**Re: Shenkman/Cavanagh – Kanata West
195 Huntmar Community Transportation Study – Addendum #1**

Section 2 of this addendum addresses the comments received from the City of Ottawa, dated November 24, 2016 in order to complete the file.

Figure 3: Revised Palladium Drive Extension Alignment

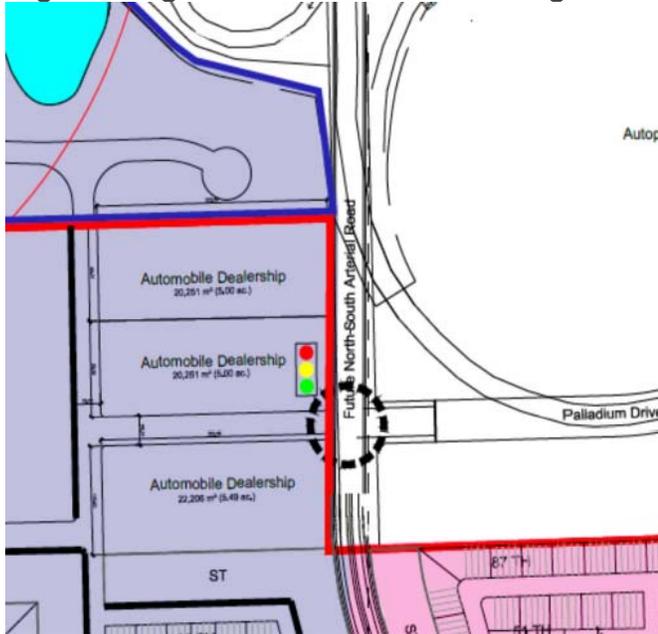
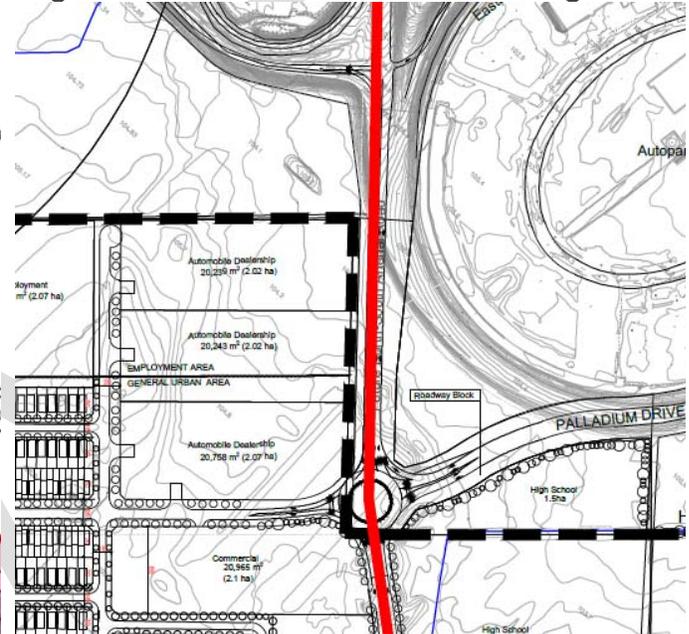
Within the original CTS, the location of the Palladium Drive extension to the North-South Arterial was proposed approximately 350m north of the planned North-South Arterial/Stittsville Main roundabout intersection and approximately 300m south of the HWY 417 eastbound off-ramp. Through consultation with the Ministry of Transportation of Ontario (MTO), we were advised that the location of the proposed Palladium Drive extension to North-South Arterial is too close to the HWY 417 eastbound off-ramp. Through further consultation with the project team, the City, and adjacent land owners, a revised location of the proposed Palladium Drive extension to North-South Arterial is proposed. The revised location is approximately 400 m south of the HWY 417 off-ramp and approximately 250 m north of the North-South Arterial/Stittsville Main intersection. The original proposed location and the revised location are shown as Figures 2 and 3, respectively.

- The revised Palladium/N-S Arterial intersection is proposed to be a multi-lane roundabout;
- The intersection is located approximately 400 m south of the HWY 417 eastbound off ramp;
- The intersection is located approximately 250 m north of the proposed N-A Arterial/Stittsville Main intersection;
- To accommodate this alignment, the land south of the Palladium Drive extension has been acquired by the proponent and will be incorporated into the proposed development as part of the high school lands;
- This revised alignment improves east-west connectivity to the site by aligning Palladium Drive with the east-west collector roadway that continues through the site to Stittsville Main Street extension.
